Recommendation Report for Planning Permission for Works or Extension to a Dwelling

REF NO: AL/41/26/HH

LOCATION: Karenza
Hook Lane
Aldingbourne
PO20 3TB

PROPOSAL: Single storey side extension, new chimney, roof extension including raising of the ridge height to facilitate conversion of loft to habitable use including 2 No. front dormers and new front canopy.

Proposed Roof Plan

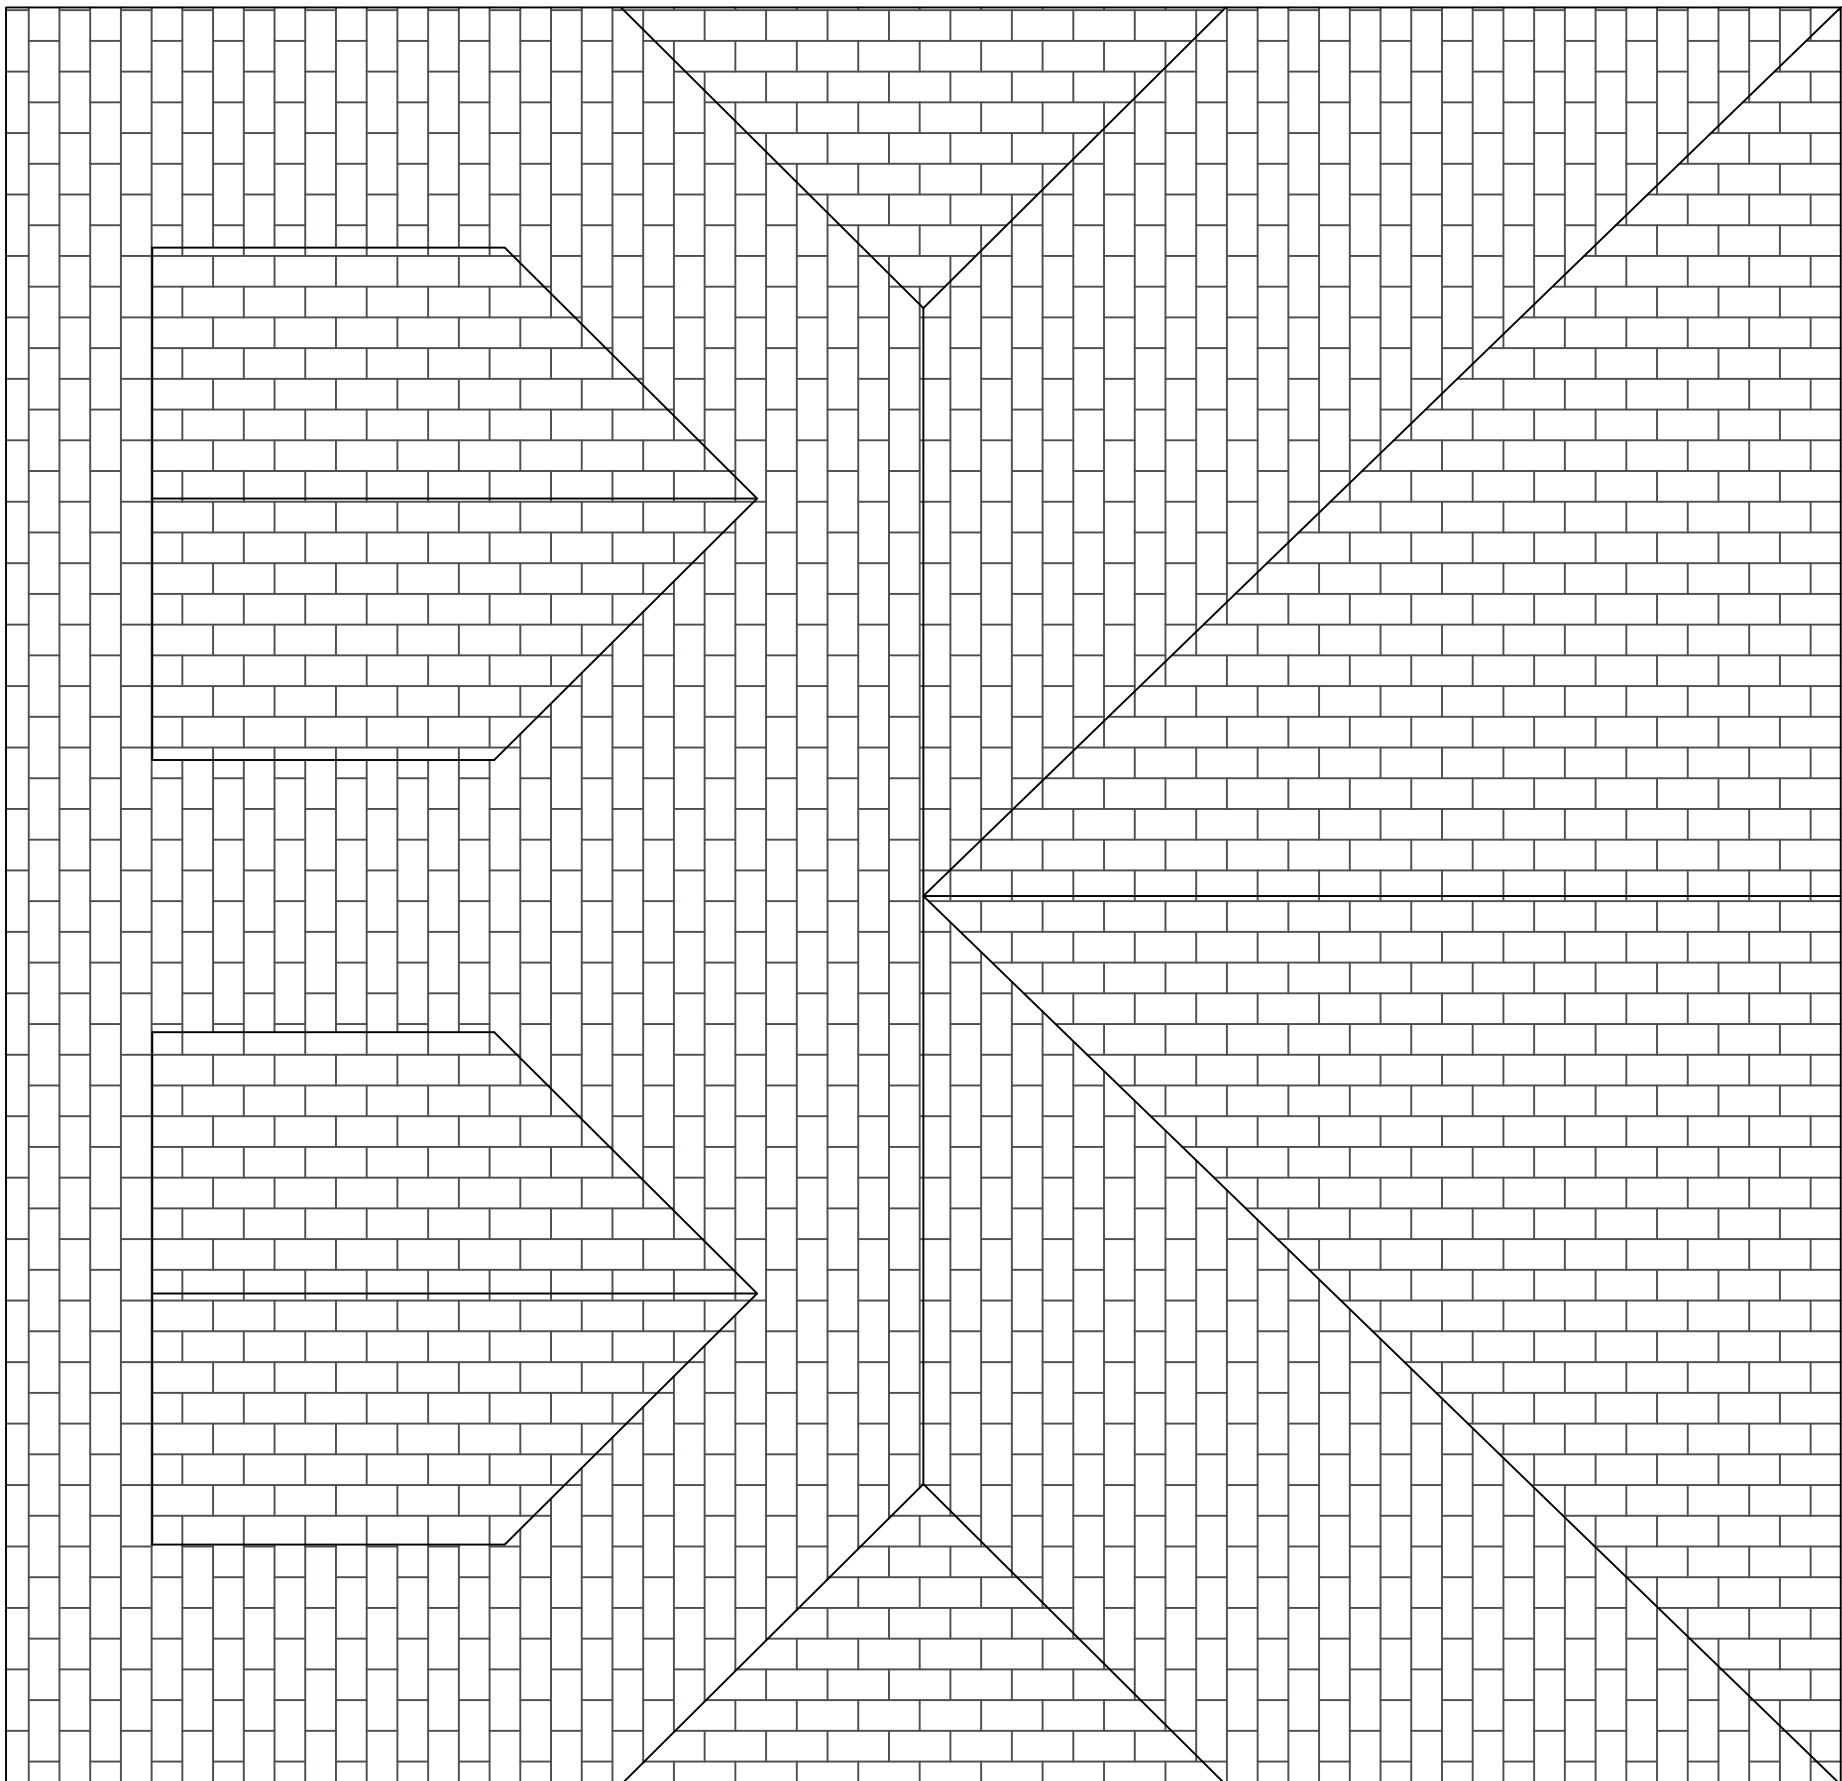
The proposed roof alterations would include the creation of a new rear gable feature, which would span the width of the dwelling following the side extension and be equal in height to the new ridge line. The new roof slopes would slope towards the centre of the dwelling to the front and rear as the ridge line would run from west to east rather than from north to south as existing. The clipped side gables would help reduce the overall bulk following the substantial increase in roof form. Given the existing variation within the wider locality and street scene with regards to roof forms, the proposed alterations to the roof would not result in harm to visual amenity, albeit an increase in bulk and massing of the dwelling.
